**Wentworthville Public School Redevelopment (SSD 9273)
70-100 Fullagar Road, Wentworthville
Notice of Exhibition**

TfNSW has reviewed the exhibited Environmental Impact Statement (EIS) supporting the proposed development. Comments on the proposal have been provided in **TAB A** for your consideration.

TAB A – Detailed comments on SSD 9273

DRAWING
END OF TRIP FACILITIES SITE PLAN

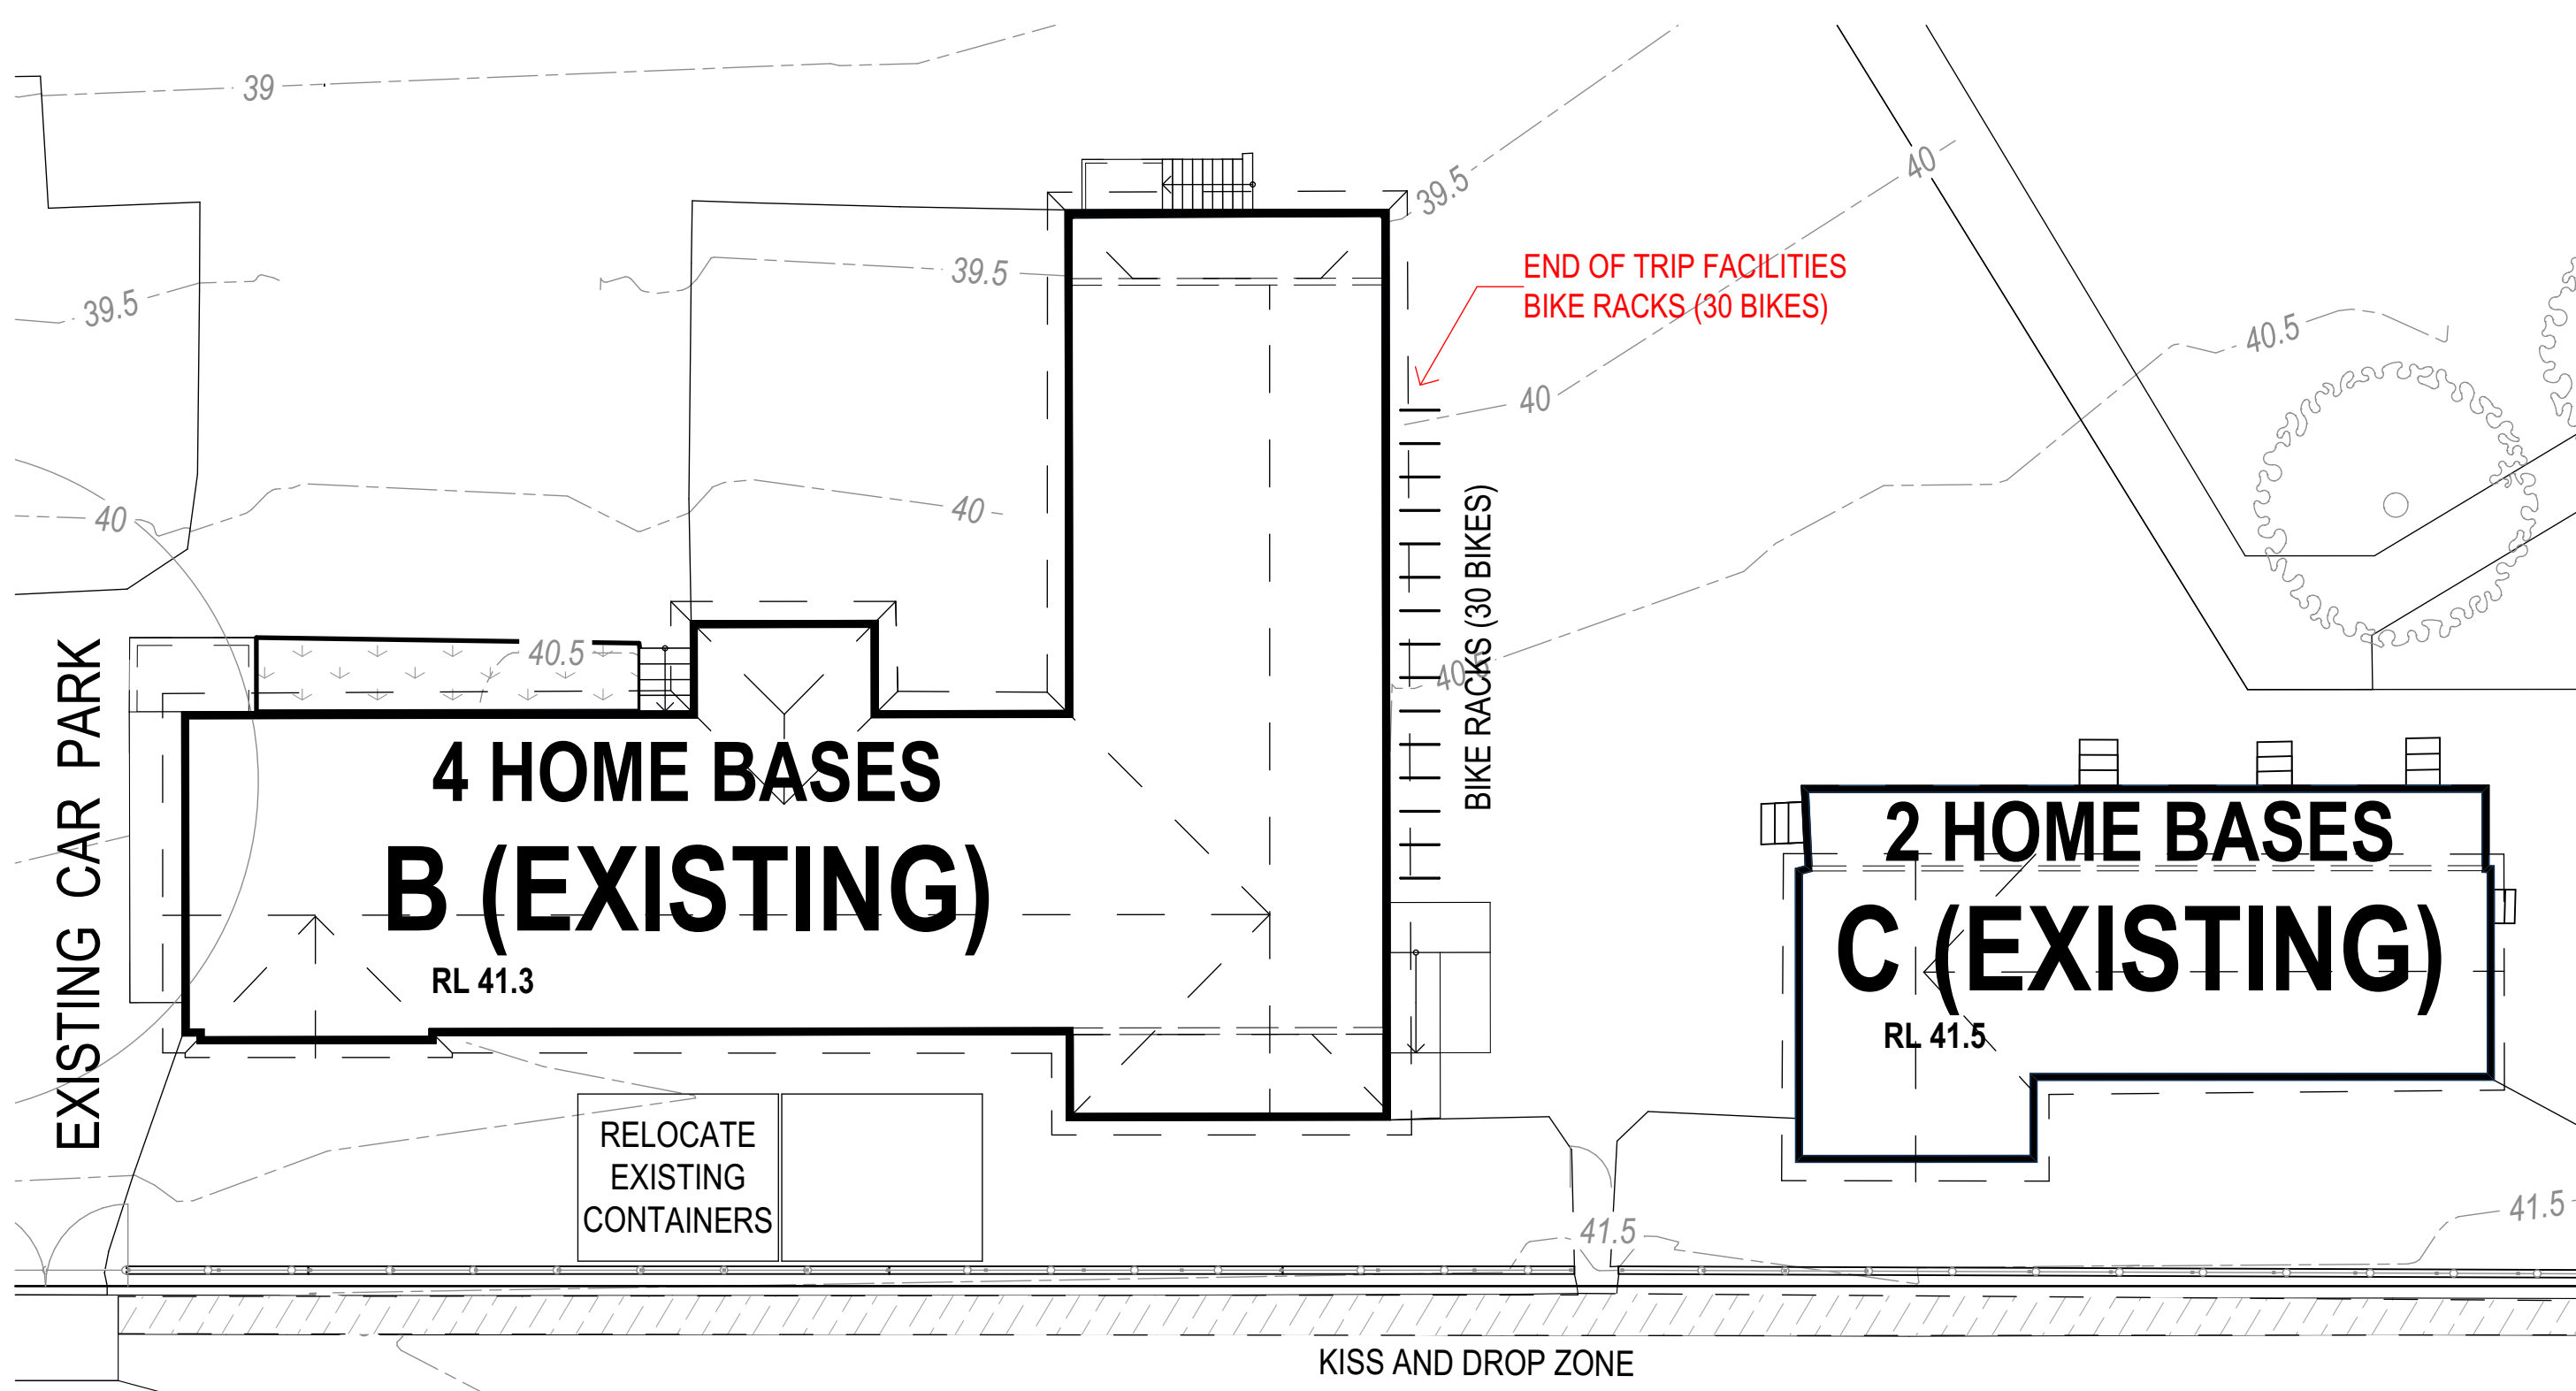
It is unclear from the traffic assessment whether there are appropriate existing end-of-trip facilities to support staff cycling trips to/from the school. If there is currently no provision for end-of-trip facilities within the school, one should be provided as part of this redevelopment proposal.

Recommendation:

DP&E and the Applicant should consider the above.
